CITY OF PORTLAND BUILDING PERMIT

Located At 38 WASHINGTON

Job ID: 2011-06-1529-CH OF USE

Conditions of Approval:

(1) PLAN AT NEW STAIR
 SCALE: 1/2" = 1'-0"

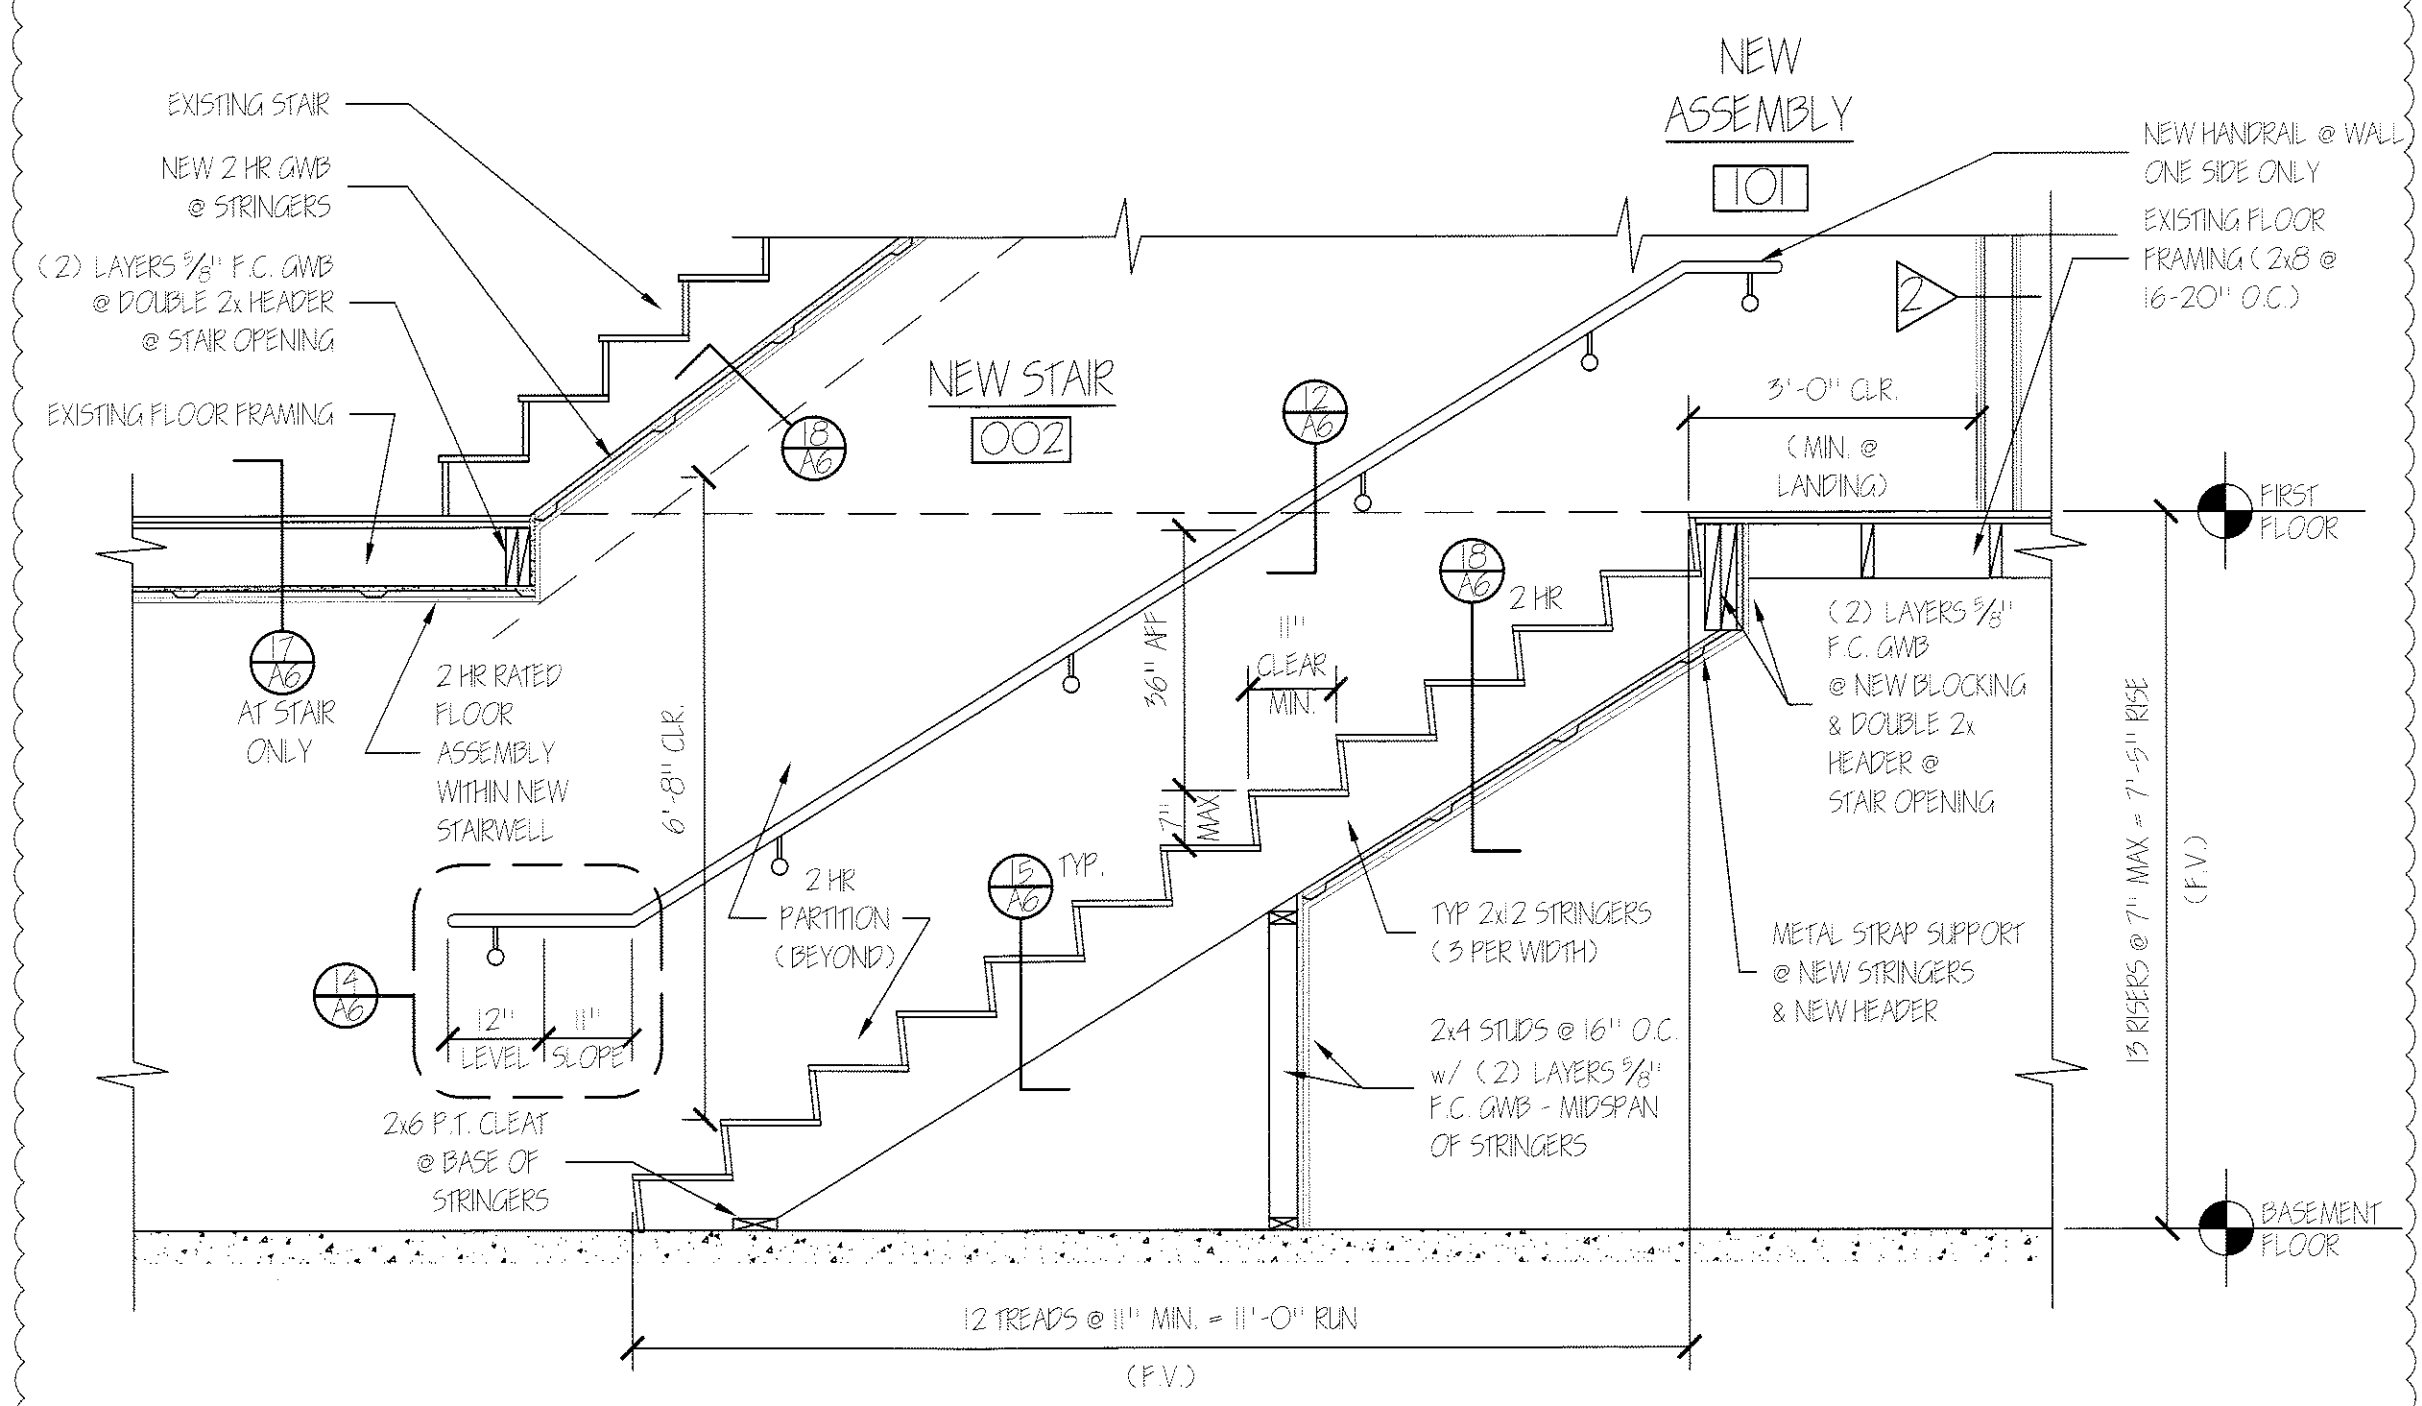
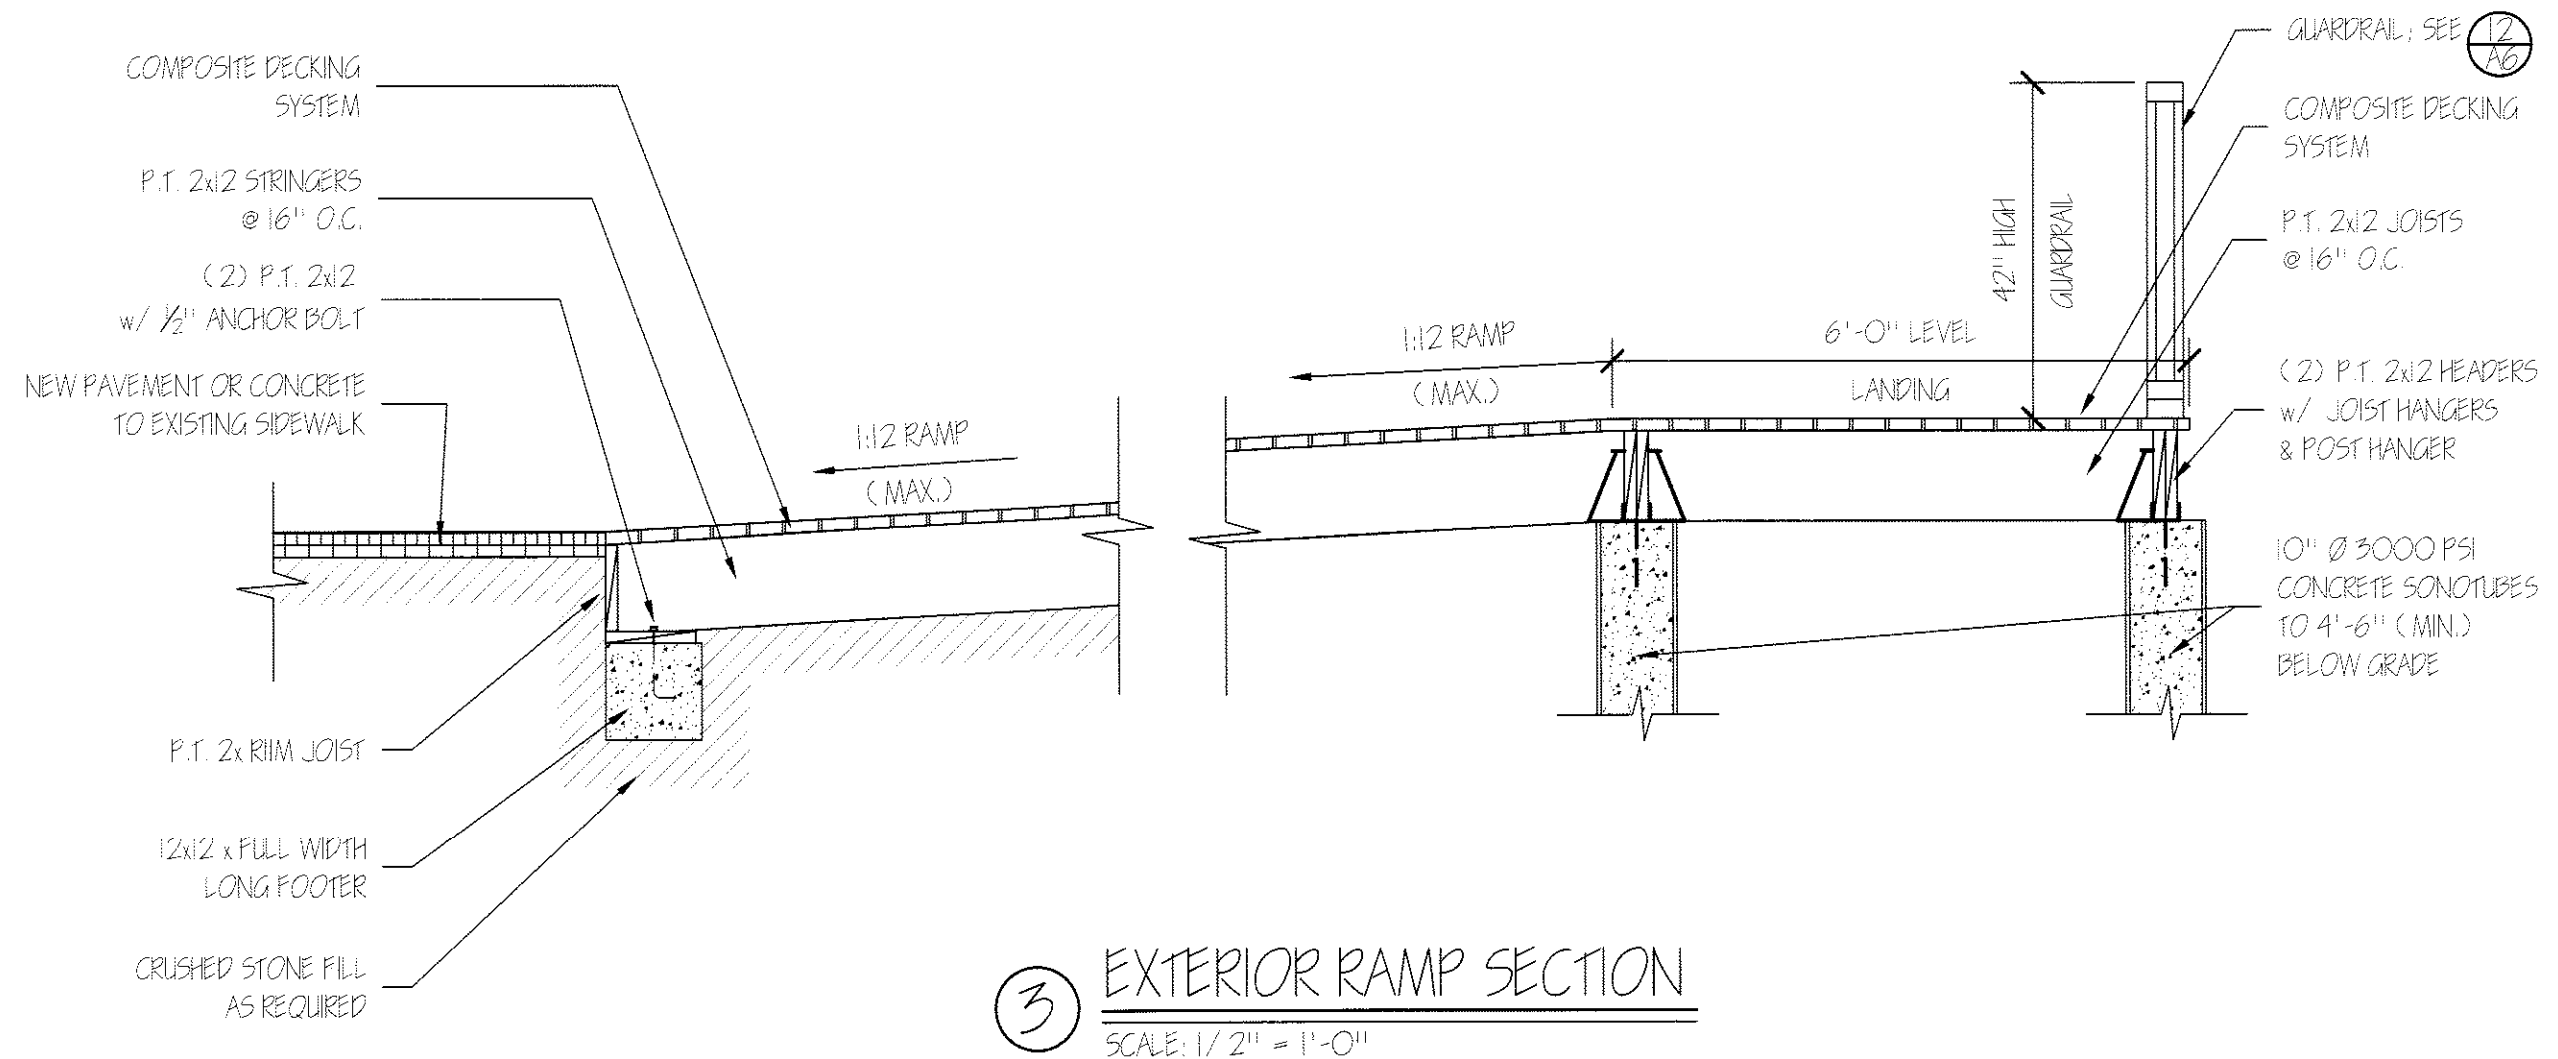
The new basement stair must maintain 6'-8" headroom minimum and have a landing between the top of the stair and the fire door.
